Five Estuaries Windfarm DCO

PINS Ref: EN010115

Date: 10 January 2025

Planning Act 2008**Application by Five Estuaries Offshore Wind Farm Limited for an order granting development consent for the Five Estuaries Offshore Wind Farm project.**

ANNEX B: OUTLINE OPERATIONAL DRAINAGE LAYOUT

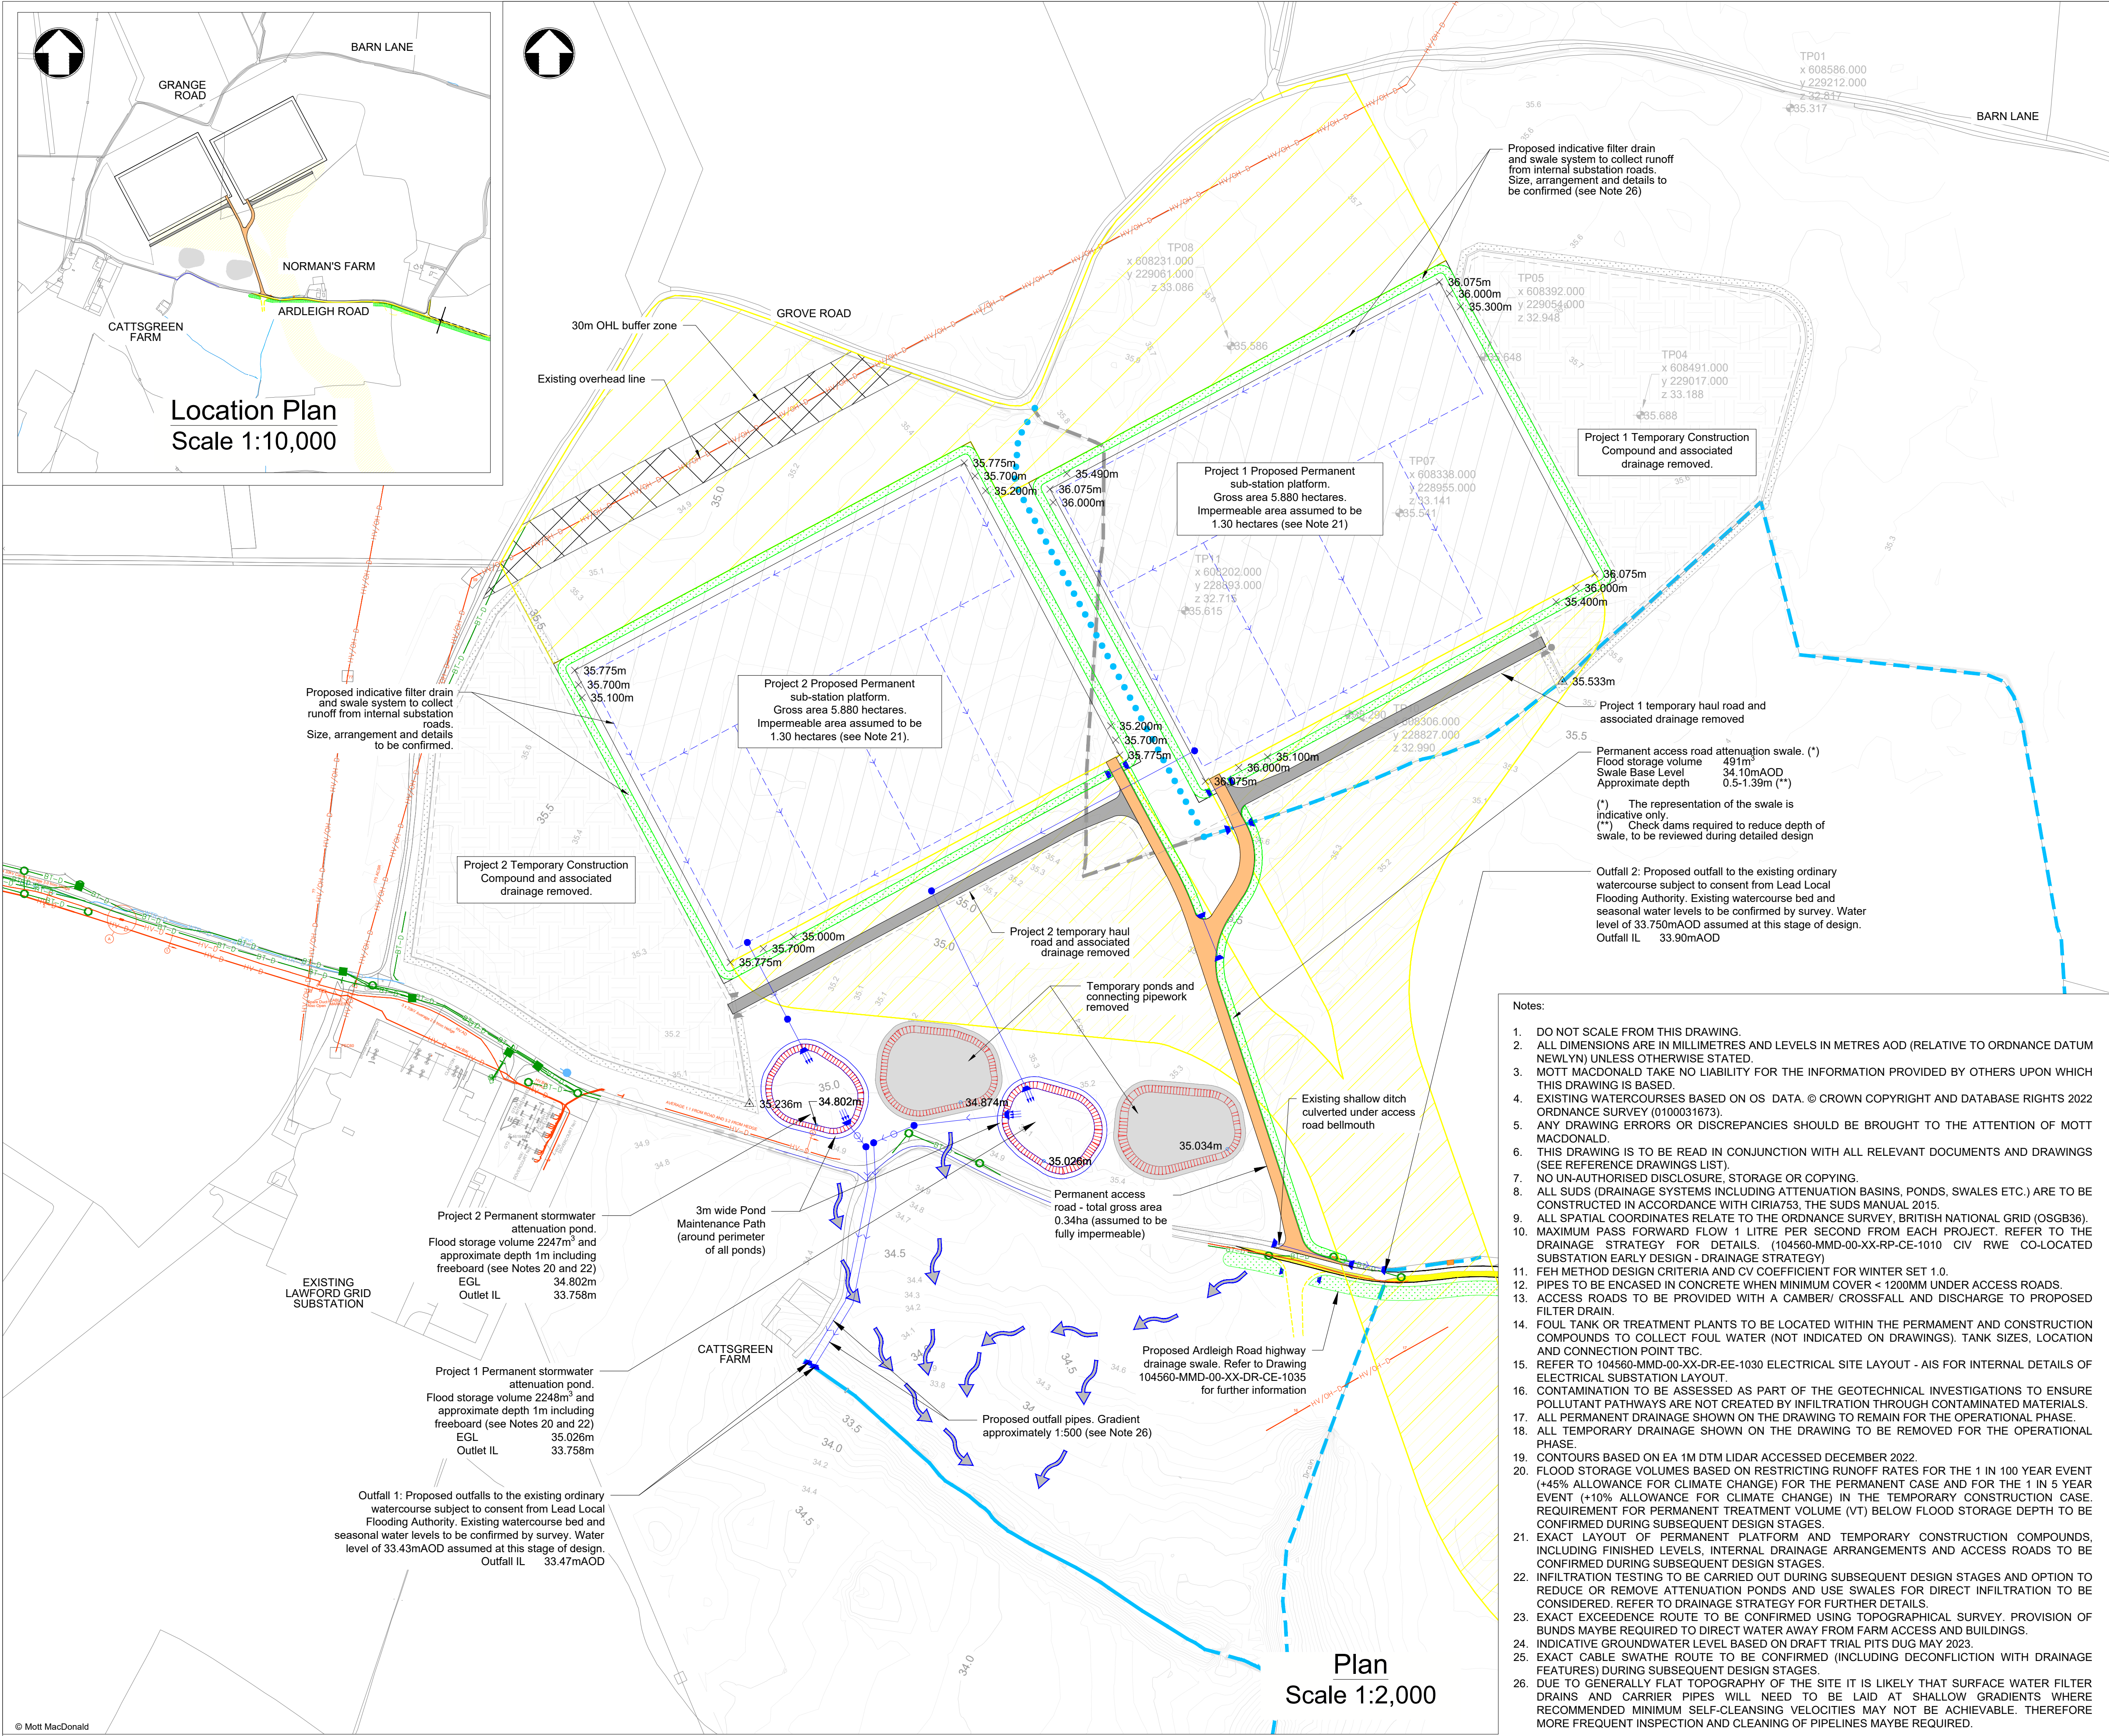
ECC Suds team have raised the following points with regard to the Onshore Substation:

- In addition to the information provided we would like to see the modelling for the drainage system for all events up to the 1in100 plus climate change.
- Confirmation of the discharge rate is required.
- How will the permanent access road drain, will it be unrestricted? Is the swale sufficient treatment for the road?
- In accordance with the Land Drainage Act 1991, Section 23 consent will be required for the headwalls and culverts.
- When will infiltration testing be undertaken? It is preferable to undertake tests in winter months when worst case scenario can be established.
